Our ref: P00493396
23 June 2016

**Arrangements for Handling Heritage Applications Direction 2015 &
T&CP (Development Management Procedure) (England) Order 2015**

**CHURCH NORTON SPIT, PAGHAM BEACH, PAGHAM PO21 4NJ
Application No P/97/15/PL**

**Block Plan Showing the
Proposed Compensation Area
(‘New Tern Island’)**

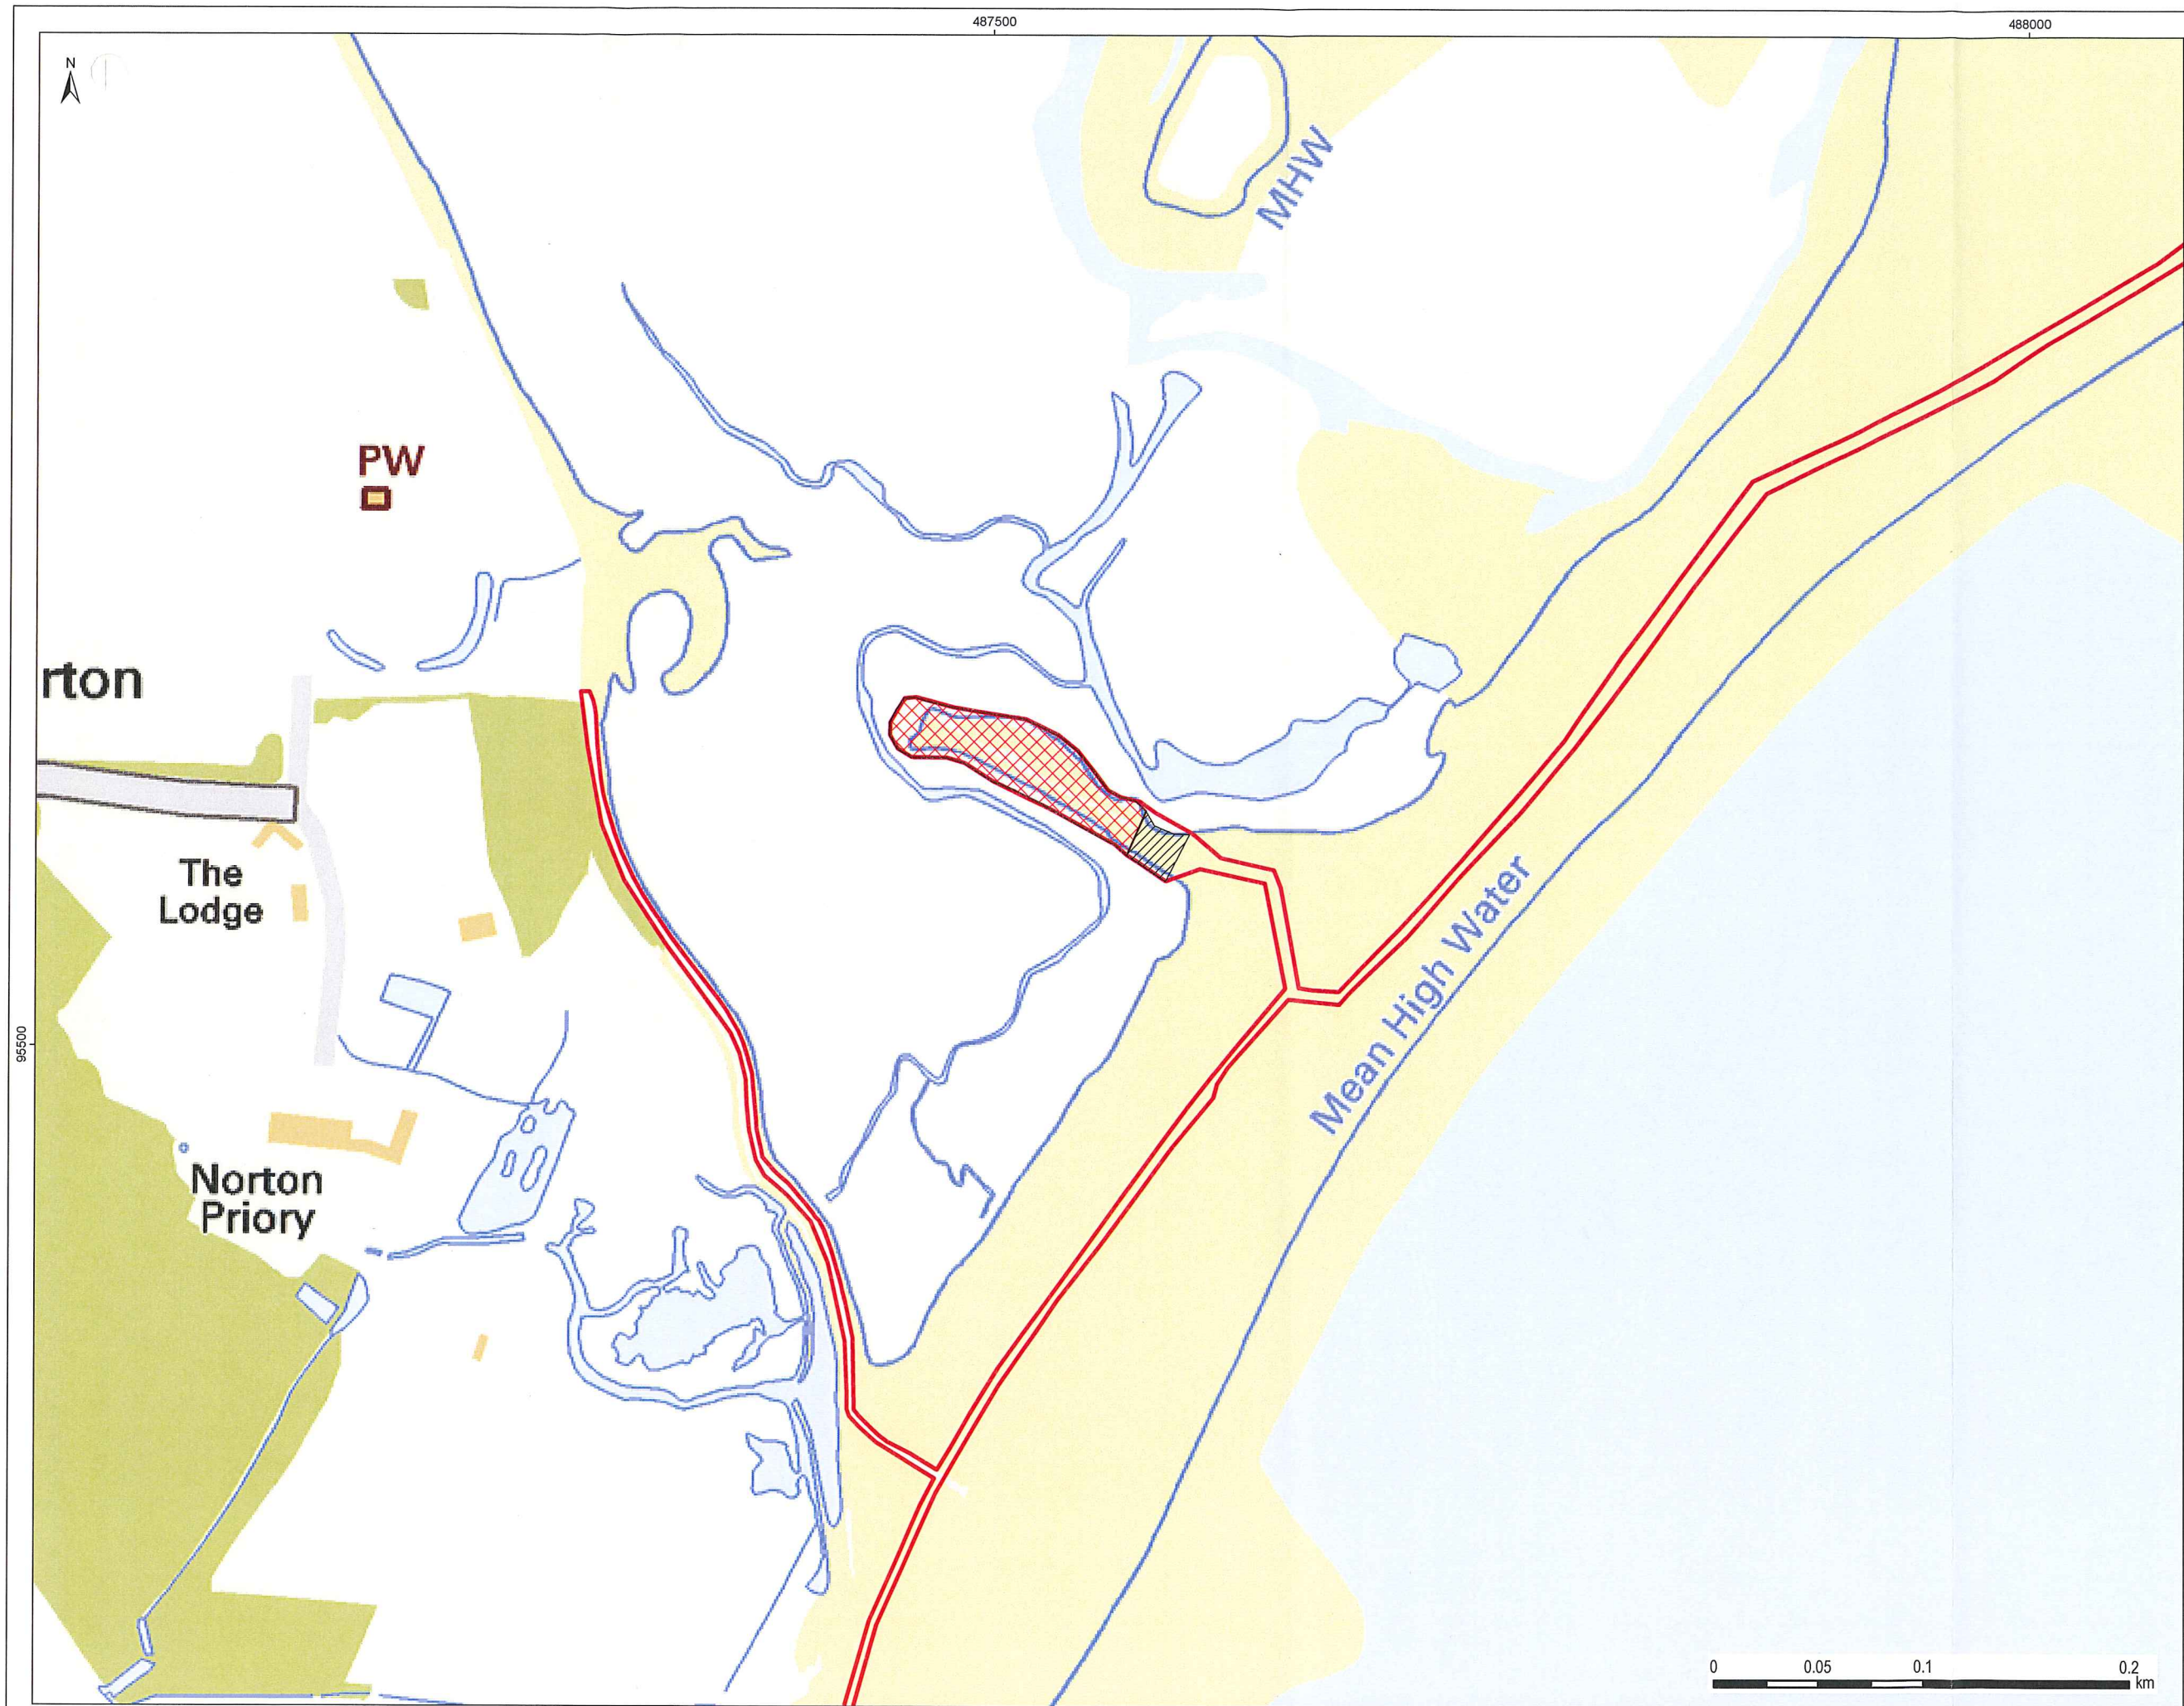
The creation of a Tern Island requires the burial of a concrete structure, identified as part of a 1930's sea defence, and excavation of a 20m wide channel to a depth of 3.5m to isolate the island from predation. The concrete structure is of limited local historic significance, and will be preserved in situ by burial under shingle. In section 4.2.4 of the submitted document, it is noted that cutting the channel would primarily affect estuarine mud and shingle of early 20th century date, and that a field drain also will have caused disturbance here. We think it is possible that this area has the potential to contain deposits of archaeological interest. This is because no archaeological survey has taken place previously in this area, the exact depths and

It will be necessary to understand more fully the nature of the deposits within the area of the channel for the Tern Island, to establish the archaeological potential and significance of the deposits surviving in the harbour. We therefore suggest that a series of boreholes are undertaken in this area to provide further detail of the deposit sequence in this area. It may also assist interpretation to undertake some supporting samples on the drier ground within the harbour. Based on the results of this investigation it may then be necessary to undertake further investigation or mitigation works ahead of, or as part of, construction of the channel.

The concrete structure that will form the Tern Island is part of the 1930's flood defences, and we suggest that a location plan and photographic record of any visible elements of the structure before burial would suffice.
